City of Portland, Maine - Building or Use Permit Application
 389 Congress Street, 04101 Tel: (207) 874-8703, Fax: (207) 874-8716

| Permit No: 05-1536 | Issue Date: | CBL: 342 B028001 |

| Location of Construction: 52 Ruby Ln #10 | Owner Name: Oak Ridge Development Inc | Owner Address: Po Box 10127 | Phone: |

| Past Use: Vacant Land | Proposed Use: Single Family Home/ Build a new 24'x 40' 3 bedroom 1 bath ranch | Permit Fee: \$996.00 | Cost of Work: \$100,000.00 | CEO District: 5 |

FRONT ELEVATION

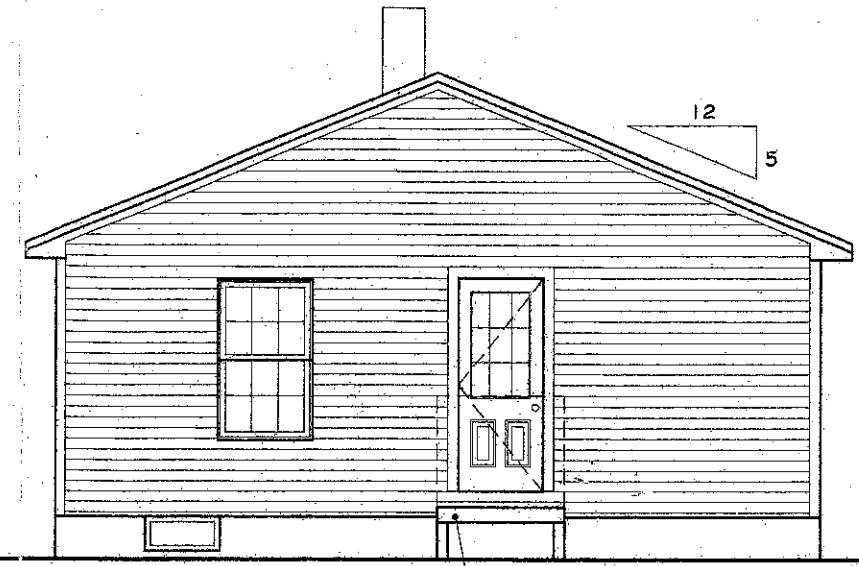
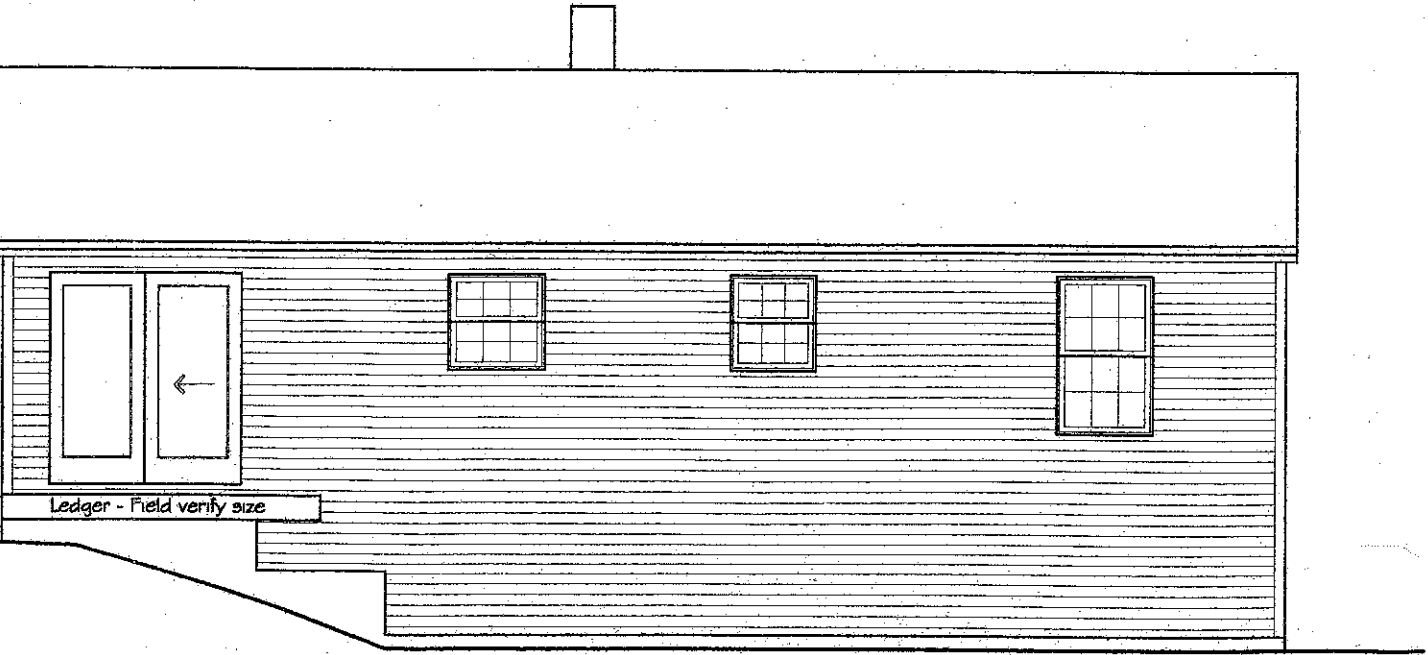
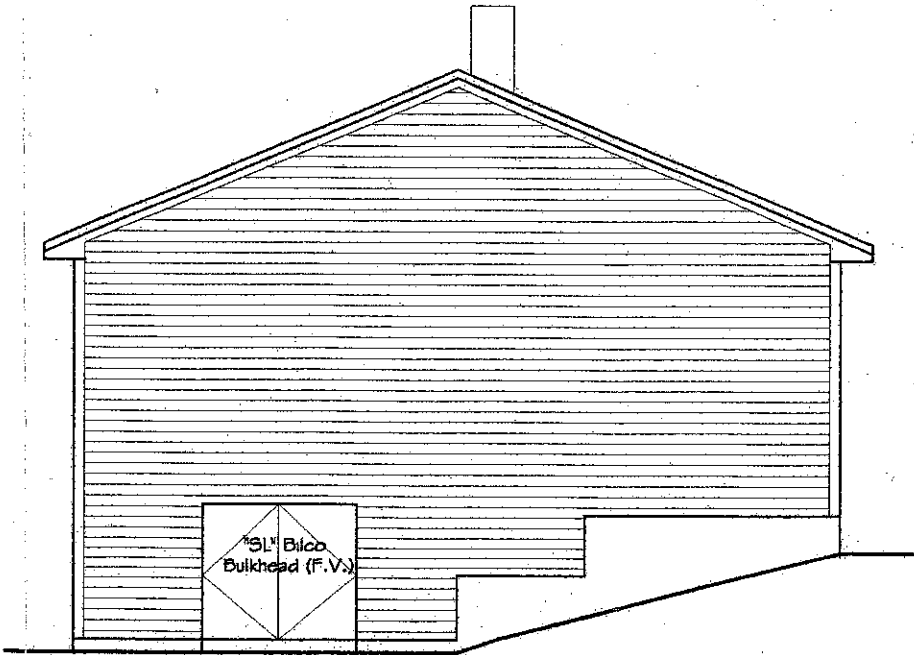
| Note: 11/01/05 Left message w/Dan. Need a deed, elevation plans not to scale & oleft & right sides confused, new site plan that shows bulkhead and side entry, & need to take out double doors on first floor plan because no room for deck out back. | | | Ok to Issue: <input checked="" type="checkbox"/> |

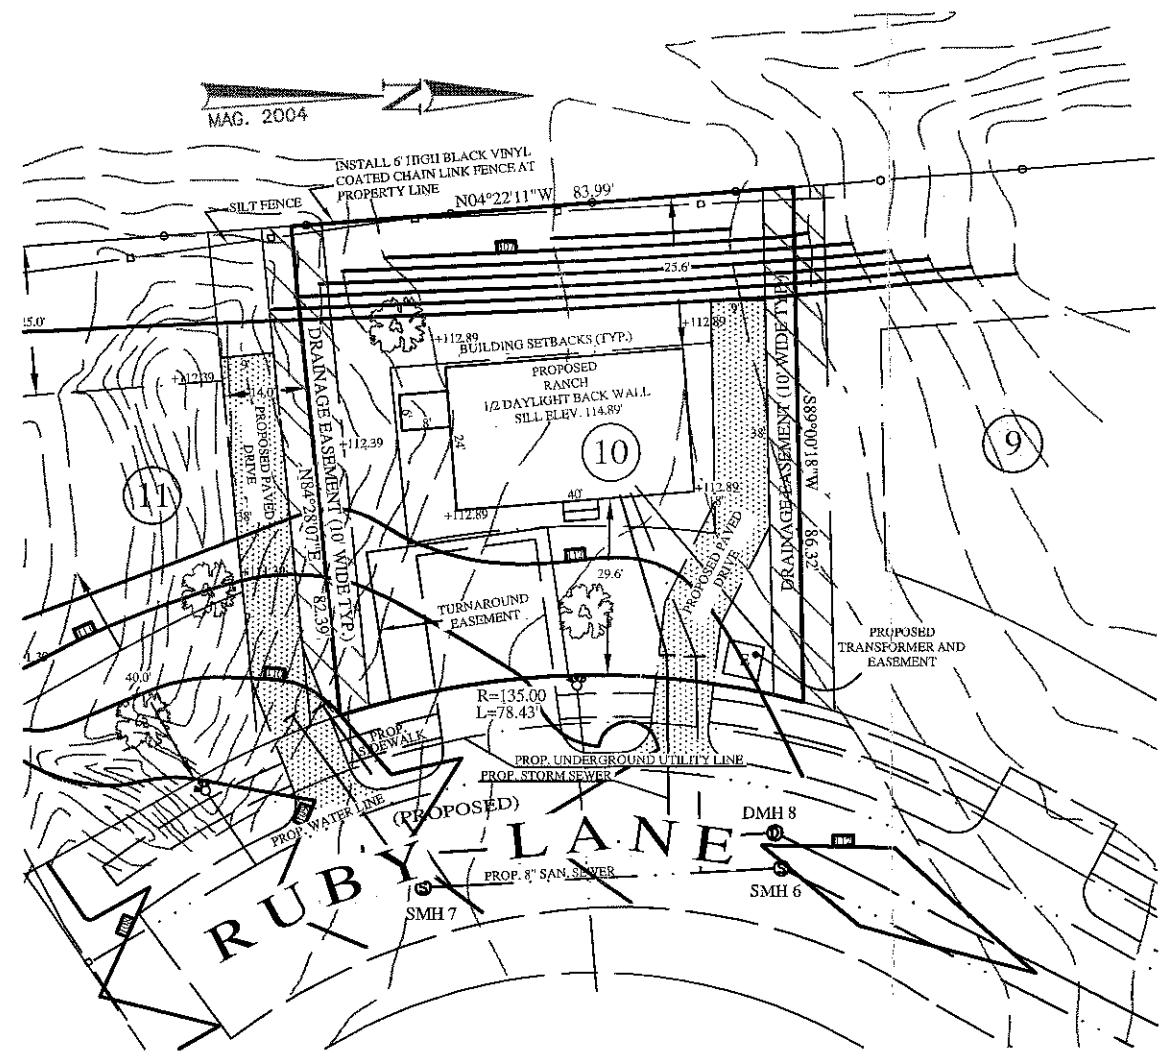
| 1) Since the front and rear setbacks are close to the foundation, the property must be clearly identified prior to pouring concrete and compliance with the required setbacks must be established. Due to the proximity of the setbacks of the proposed building, it may be required to be located by a surveyor. | | | |

| 11/10/2005-GG: received approved / revised site plan. /gg |
